Application No: R/116/21/HH
Site Address: 17 Mill Close Rustington BN16 3HR
Description of works: Erection of single storey rear extension

Thank you for your internet representation made on 13th June 2021 which has been recorded as an objection with the comments as follows:

Plans & Elevations As Proposed

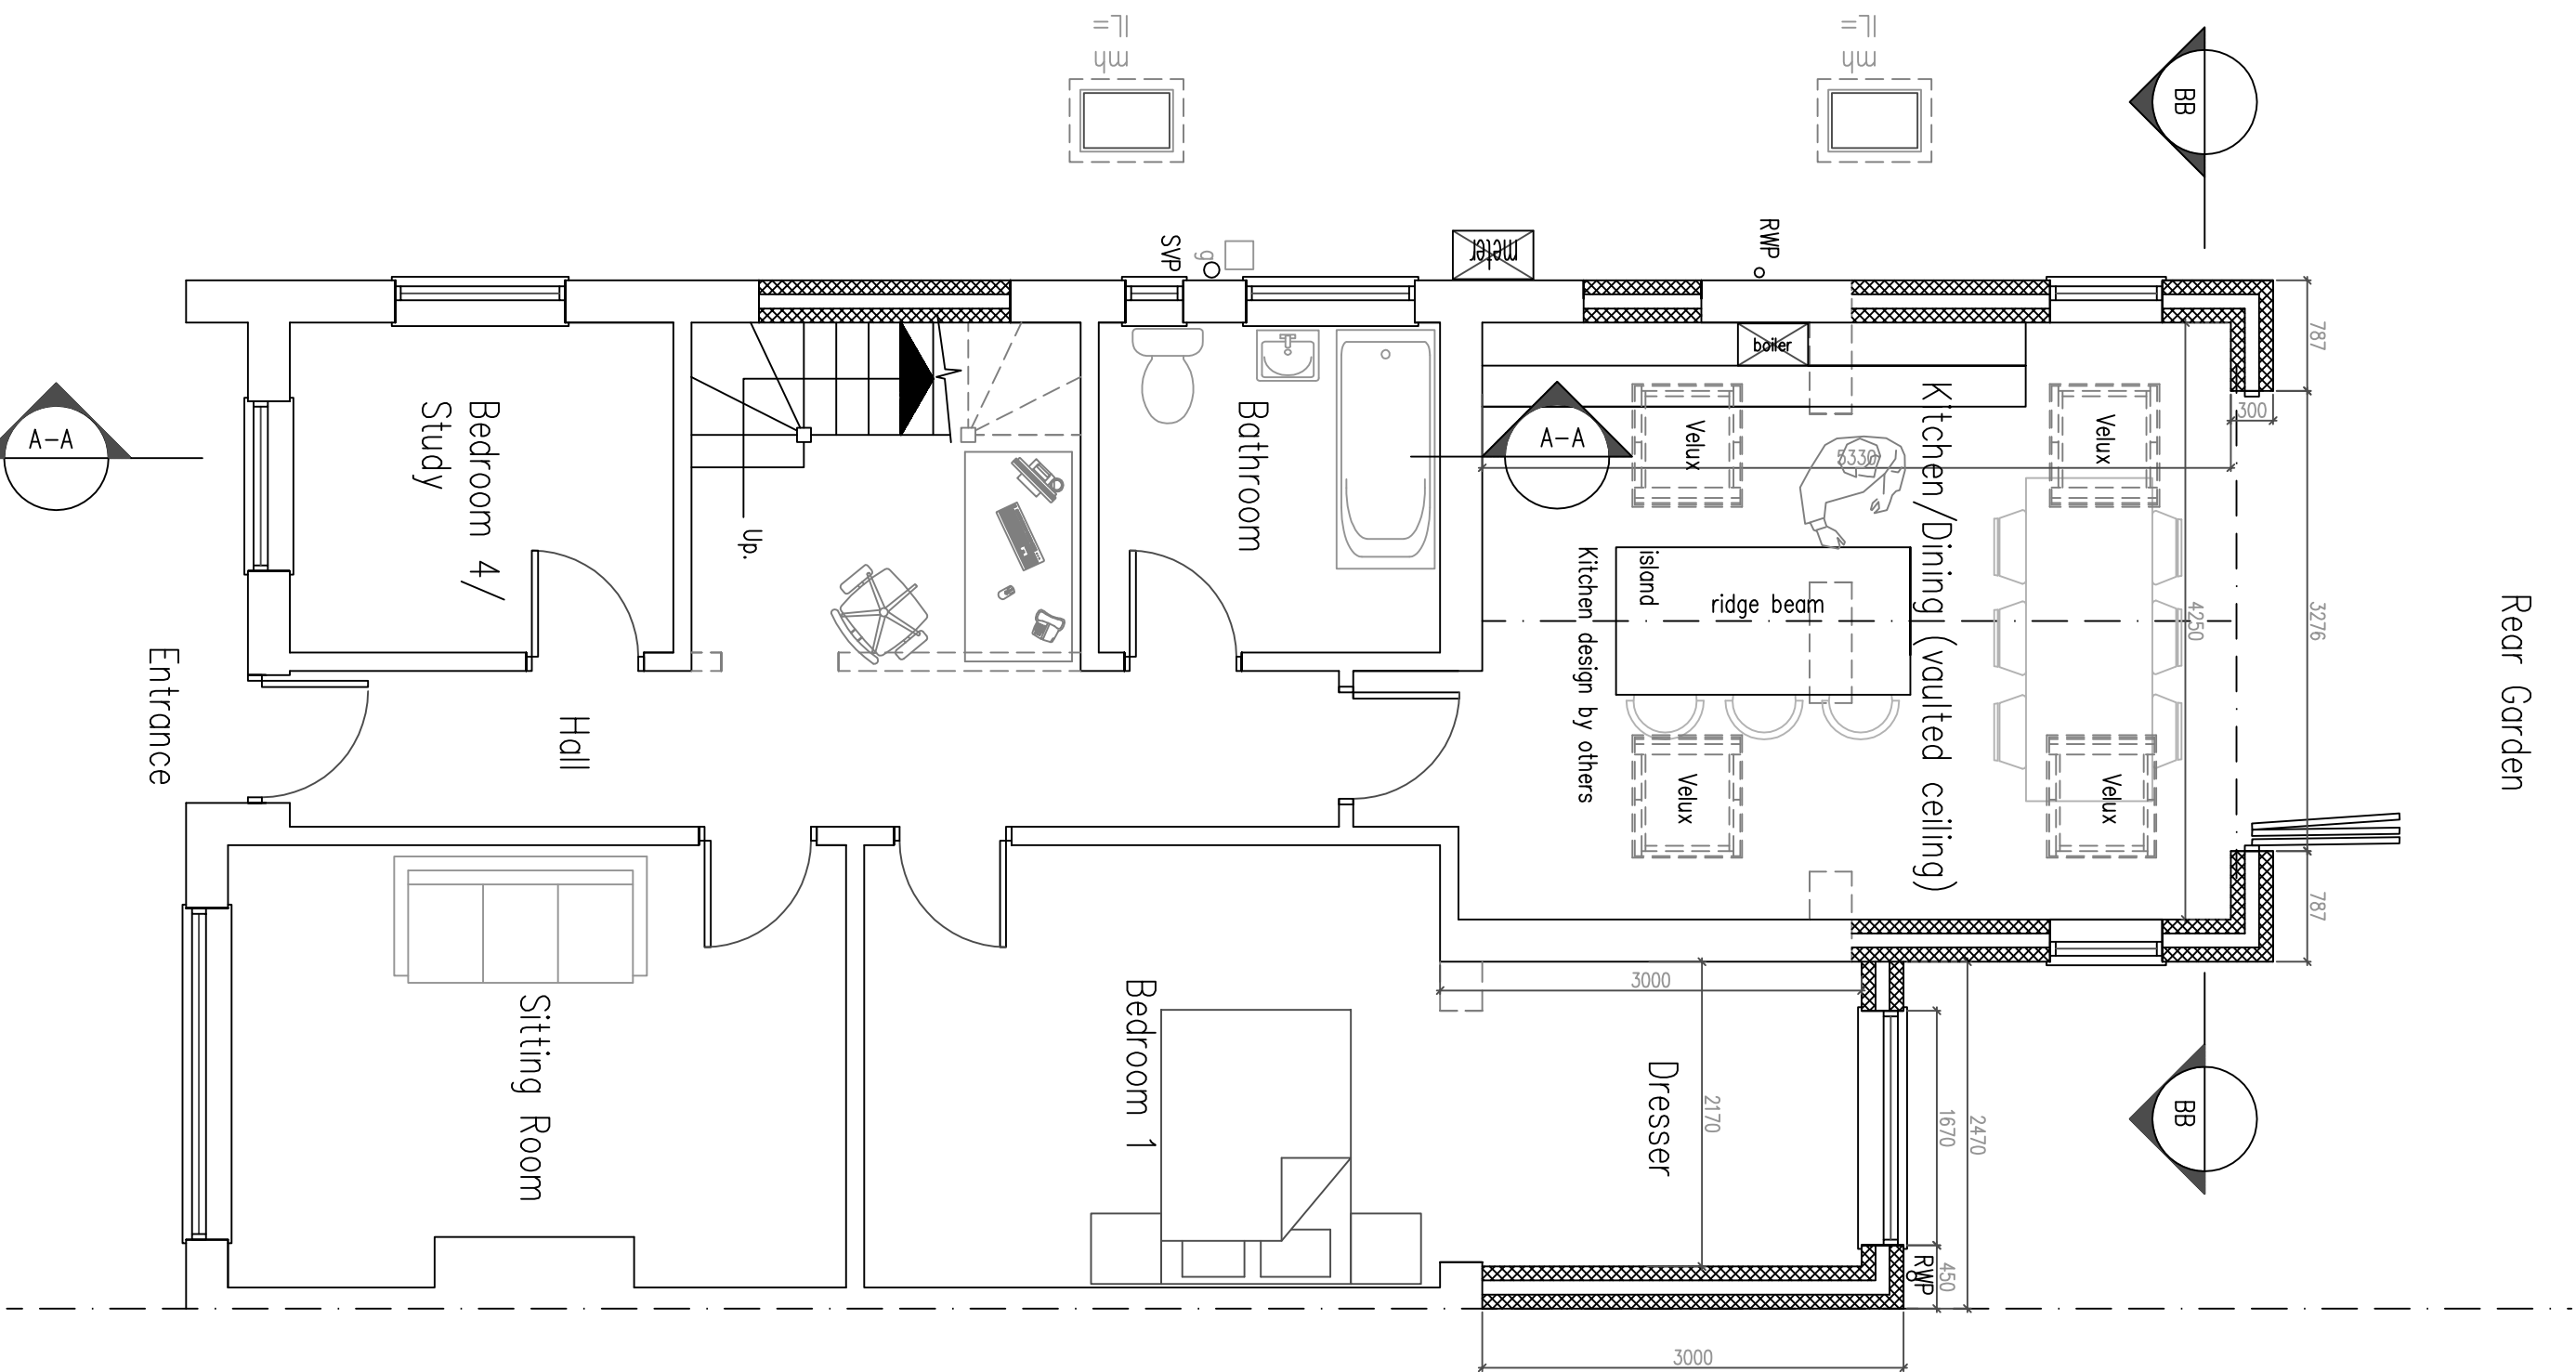
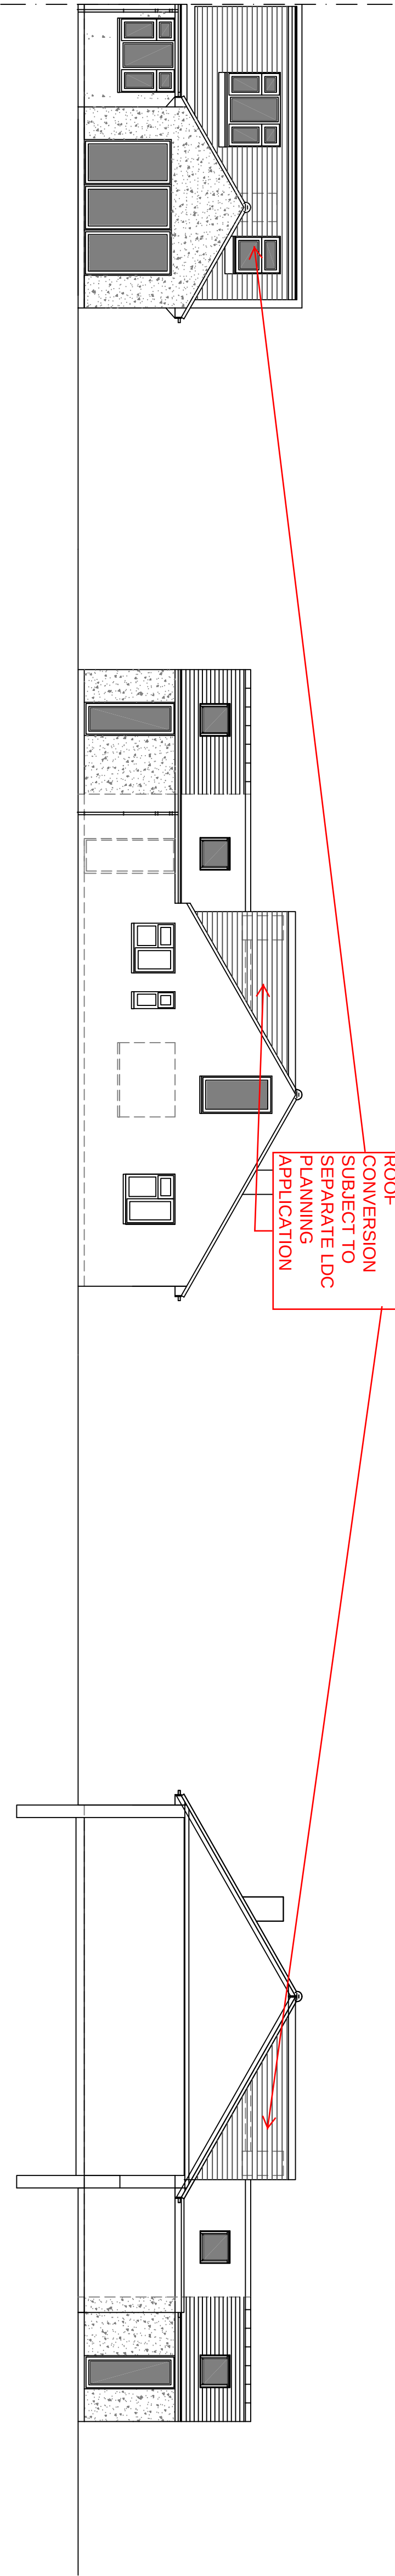
I find the plans to be hugely confusing and unhelpful. However, my objection is specifically about the overdevelopment of a single storey building in a single storey building area. Not only will this 'extension' be out of character with the rest of the locality, but the rear dormer is extremely excessive, not to mention ugly, and should be redesigned in a more aesthetic way and in keeping with the rest of the property and locality.
